Date: 10th September 2025

**Address: BAE Systems Samlesbury Aerodrome Myerscough Smithy Road
Balderstone BB2 7LF**

**Proposal: Proposed extension to manufacturing facility with associated HV
Substation, external plant compound and new/displaced car park.**

Lancashire County Council

Project:	7295								
Title:	Proposed Car park Site Plan (Planning) - Reduced								
Project no:	7295	Scale:	As indicated	Drawn by:	JL	Checked by:	KC	Date:	24/09/2025
Drawing no:	OSE-WMA-XX-DR-A-00-020	Status:	D2	Rev:	P02

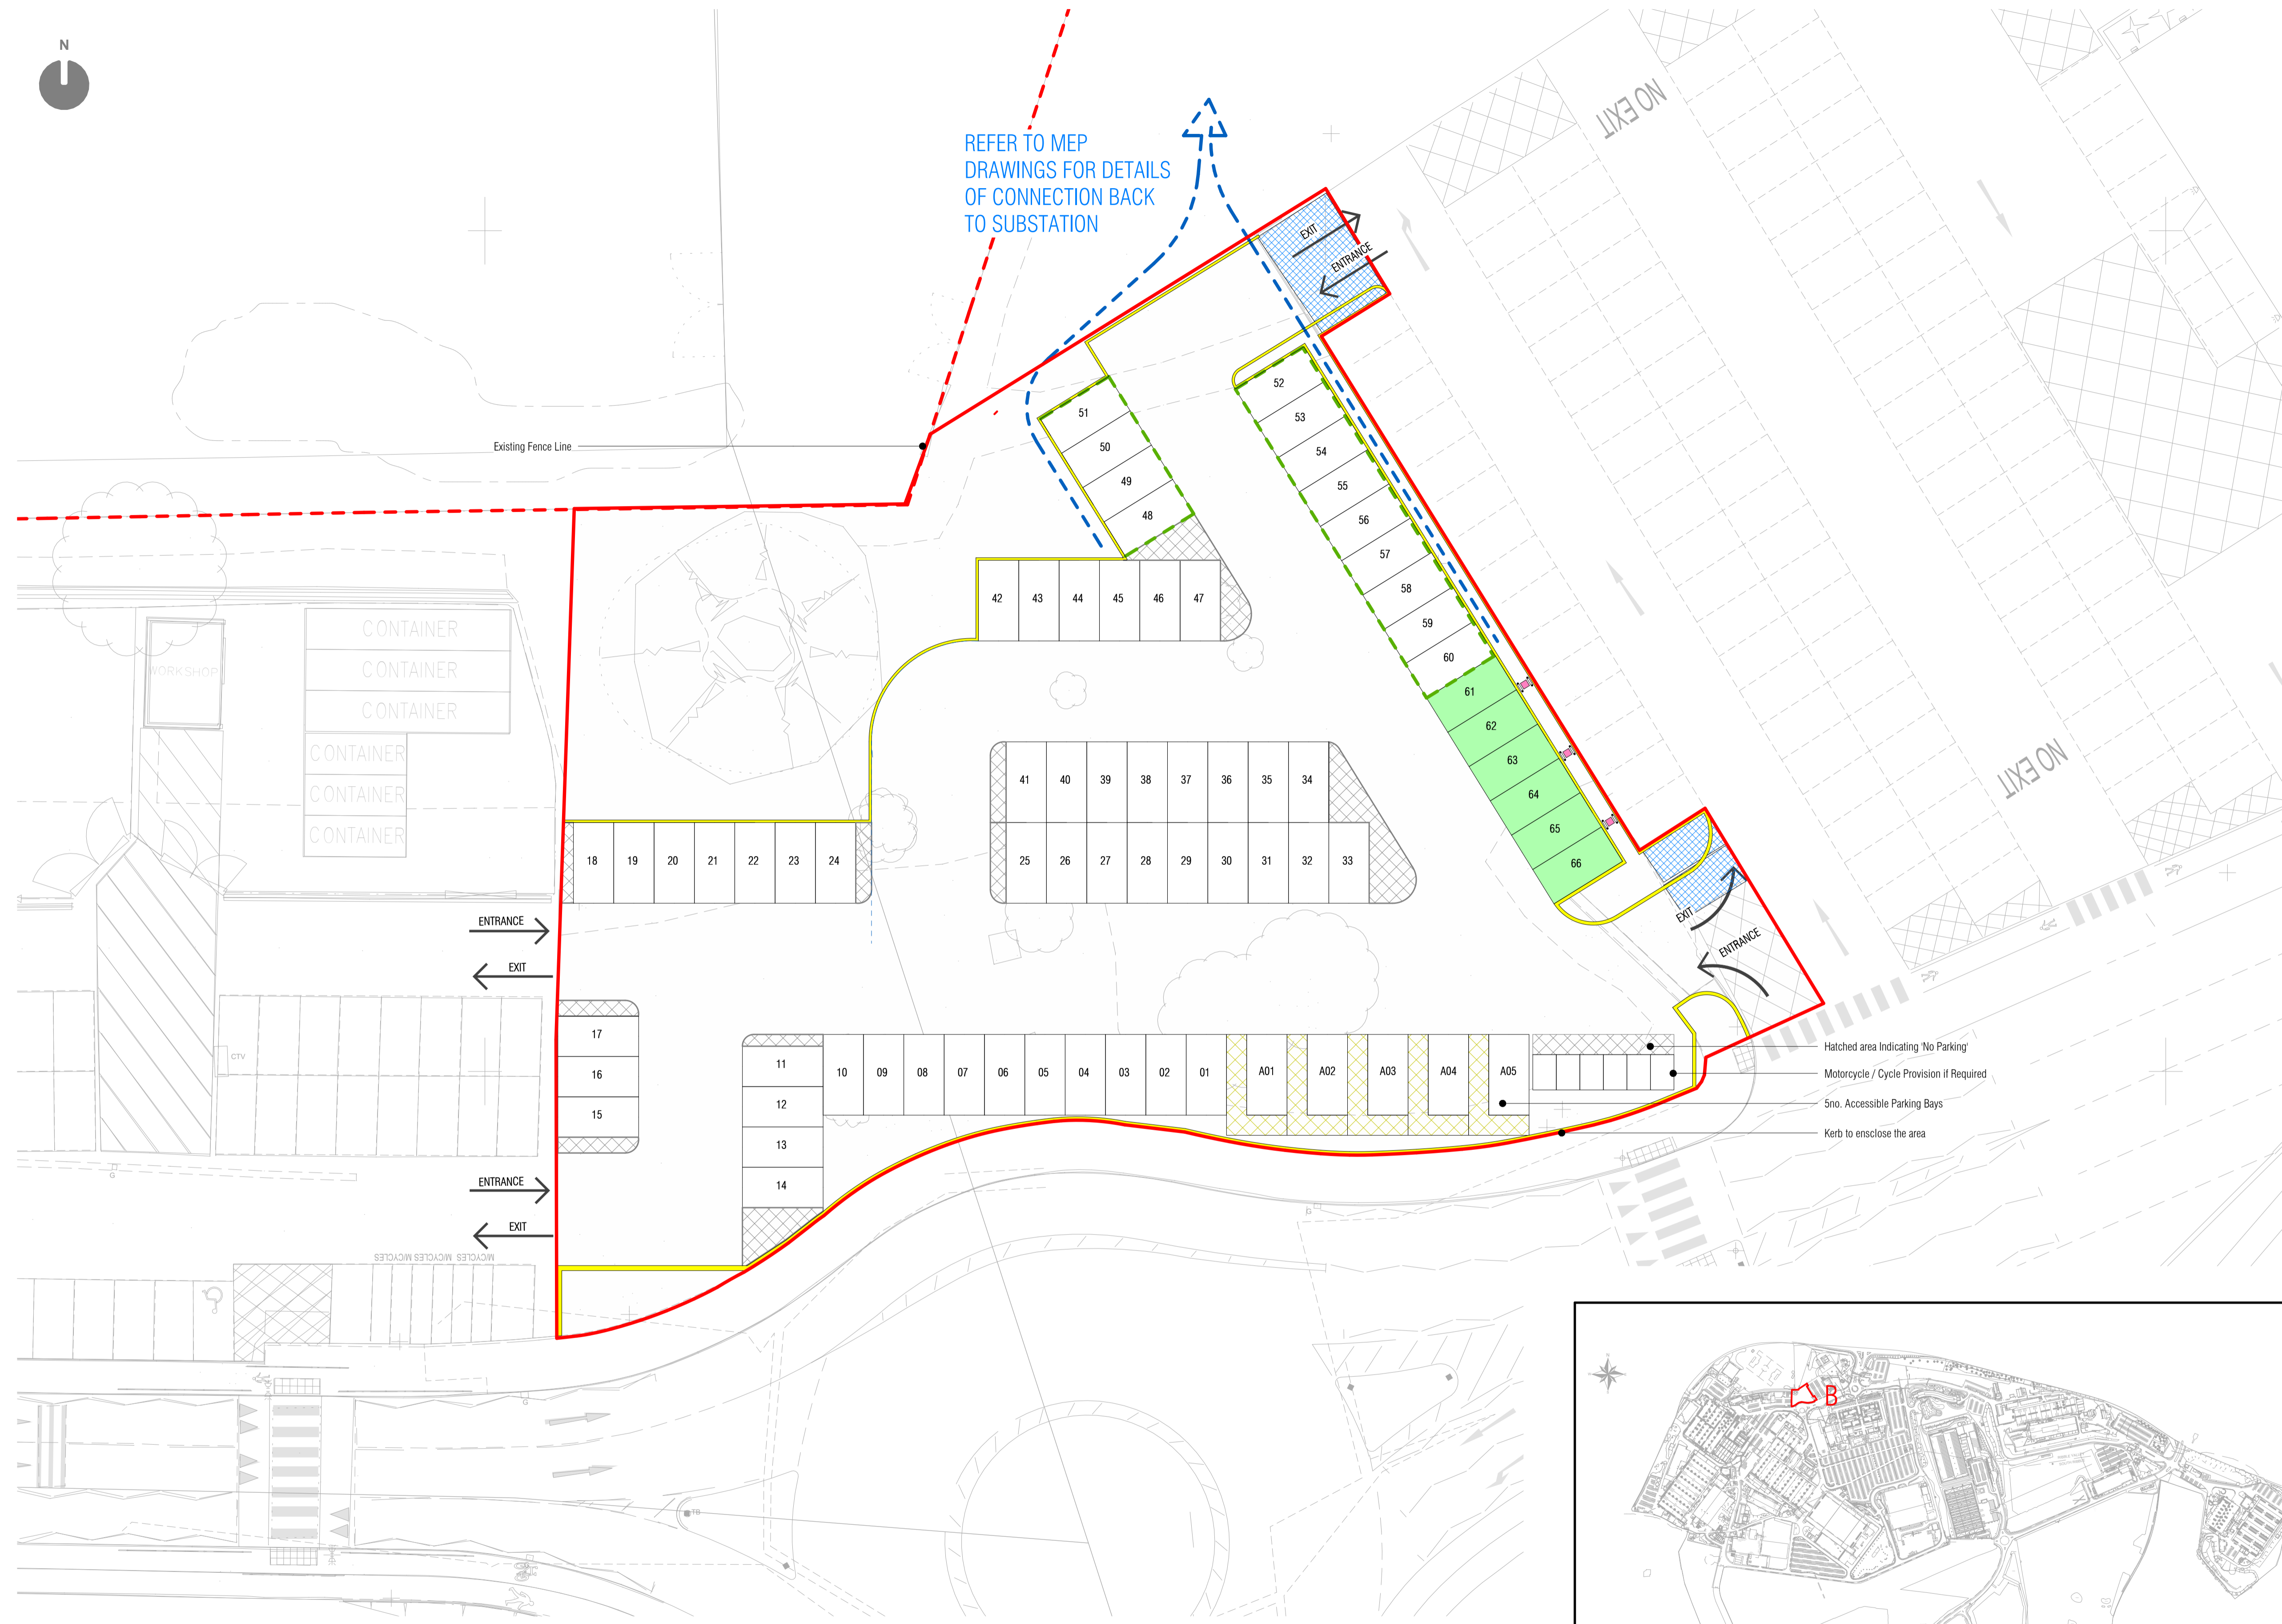
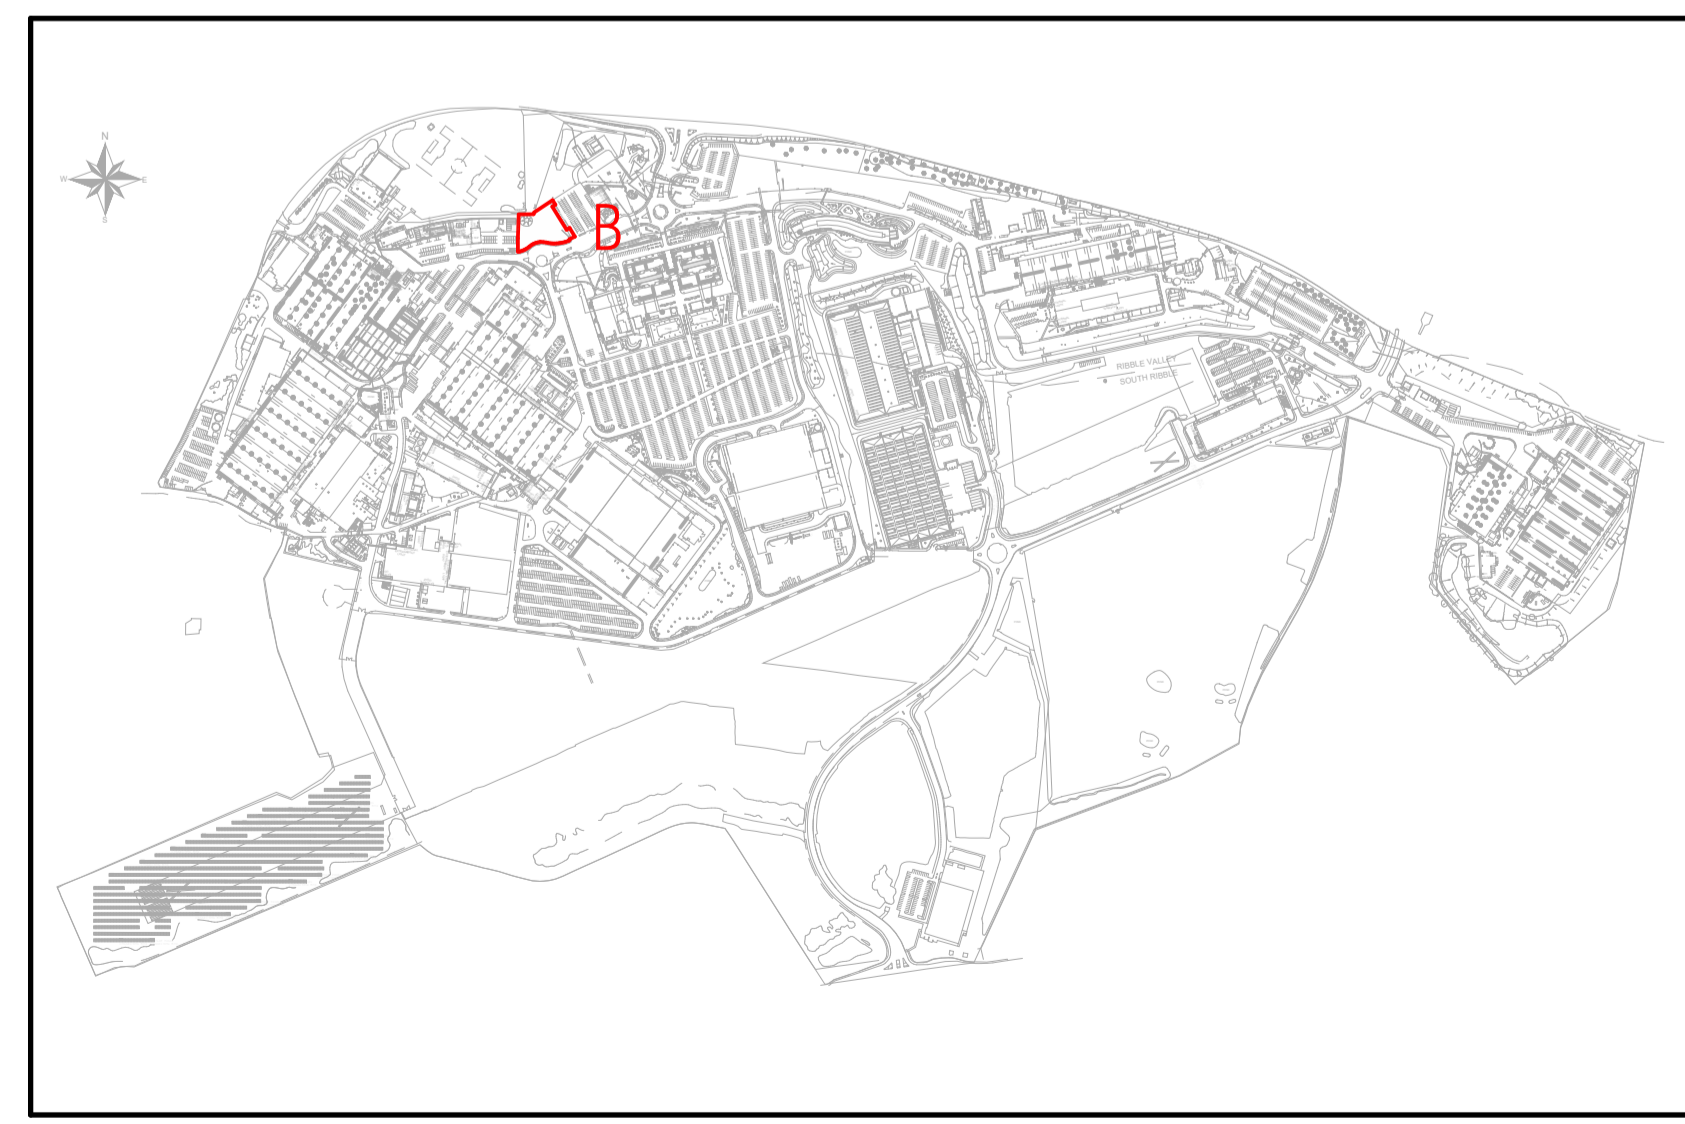
A new car park for 90 cars is proposed, including 5 accessible spaces and 6 EV charging. There are 6 motorcycle spaces proposed.

The extension results in the loss of 55 car parking spaces, including 2 accessible spaces, the sub-station site results in the loss of 10 car parking spaces and the new car park results in a loss of 5 spaces, totalling 70.

Overall, there is a net increase of 20 spaces at the site.

Based upon a B2 facility of 1800sqm we would expect to see a parking provision of 40 spaces, reduced to 26 if considered to be a highly accessible site with on-site facilities. This is a shortfall however there are no additional employees proposed as a result of the proposal therefore demand is not anticipated to increase.

It is noted that there is no active car park management of where staff park in the various car parks across the site. The Highway Authority has no reports of overspill car parking from the site onto the surrounding highway network.

We would consider the car parking provision to be acceptable.

We would request that secure and covered cycle parking is provided to support staff to travel sustainably to site, if not already provided at the site.

1. Prior to first use of the development hereby permitted the replacement car parking shall be provided in accordance with the approved plan. Reason: To provide adequate car parking on site.
2. Prior to first use of the development hereby permitted a secure and covered cycle store for 9 bicycles shall be provided and maintained thereafter. Reason: To support sustainable travel.
